Your Ref: OWQC15817
Our Ref: BE/113/17/RES
Please ask for:
Mr D Innes

Approval of reserved matters following outline consent BE/18/17/PL for appearance, landscaping, layout & scale for a mix of up to 90No. residential units, associated open space, landscaping, access & car parking
Land West of New Barn Lane Bersted

Thank you for your internet comments made on 11th October 2017 which has been recorded as '**no objection**' with the comments as follows:

DEVELOPMENT SCALE AND MASSING

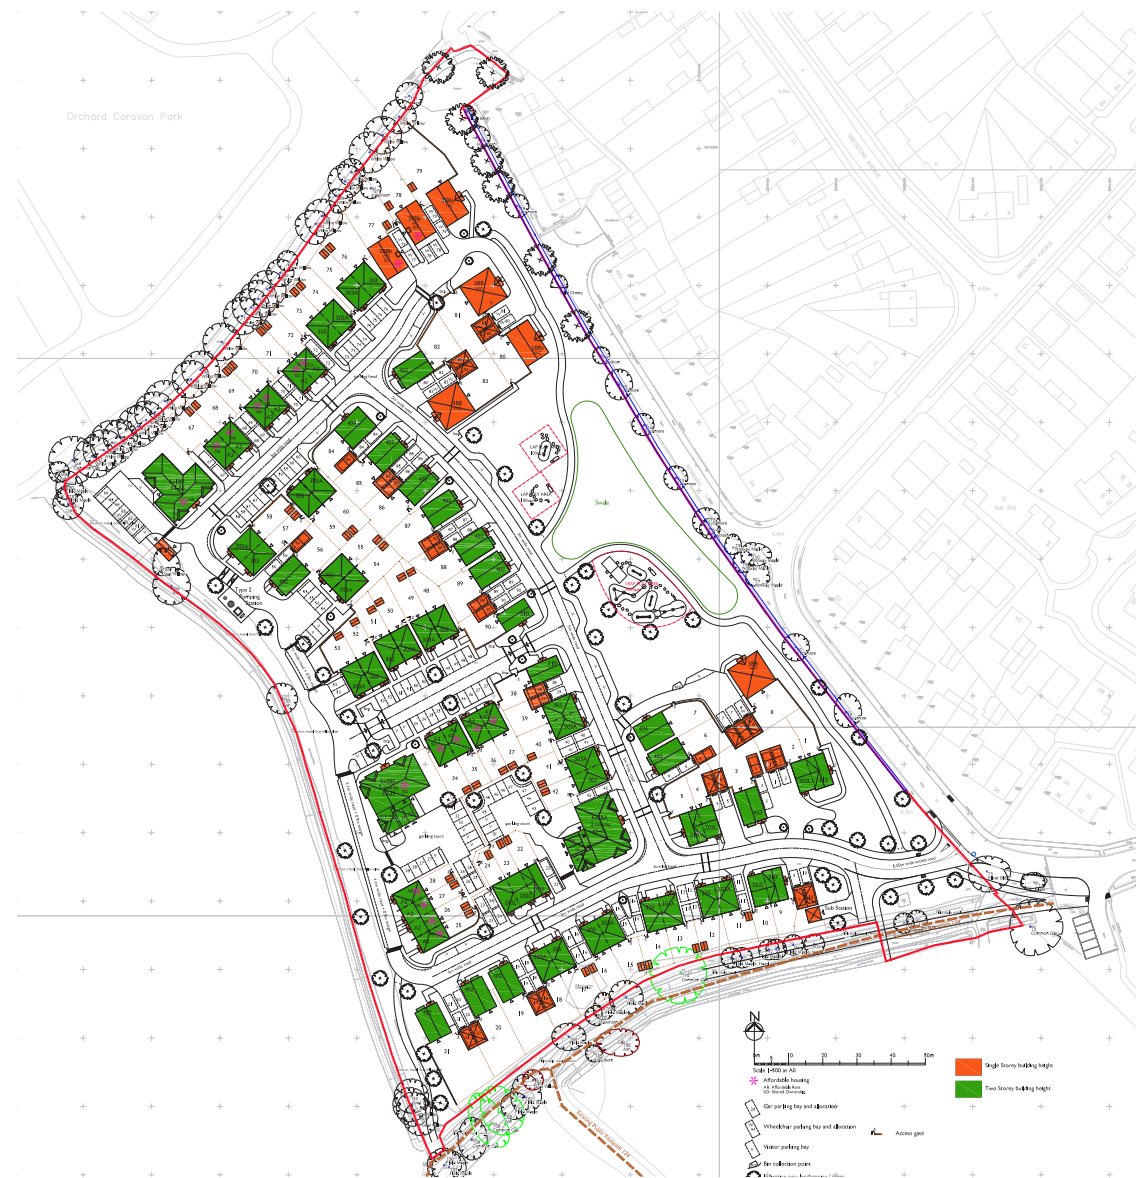
*NO OBJECTION but members would like to make the following comment: -
Plots 1 & 2 are not in keeping with Bersted Neighbourhood Plan policy HDQ2 Integration of new housing, even though permission for 2 storey dwellings at this location has been granted via BE/18/17/PL. The Parish Council would ask that the developer considers changing plots 1 & 2 to bungalows so that they blend better with the surrounding area and are not so over-bearing on the existing bungalows opposite.
The site generally has a good mix of housing to meet the needs of Bersted.*
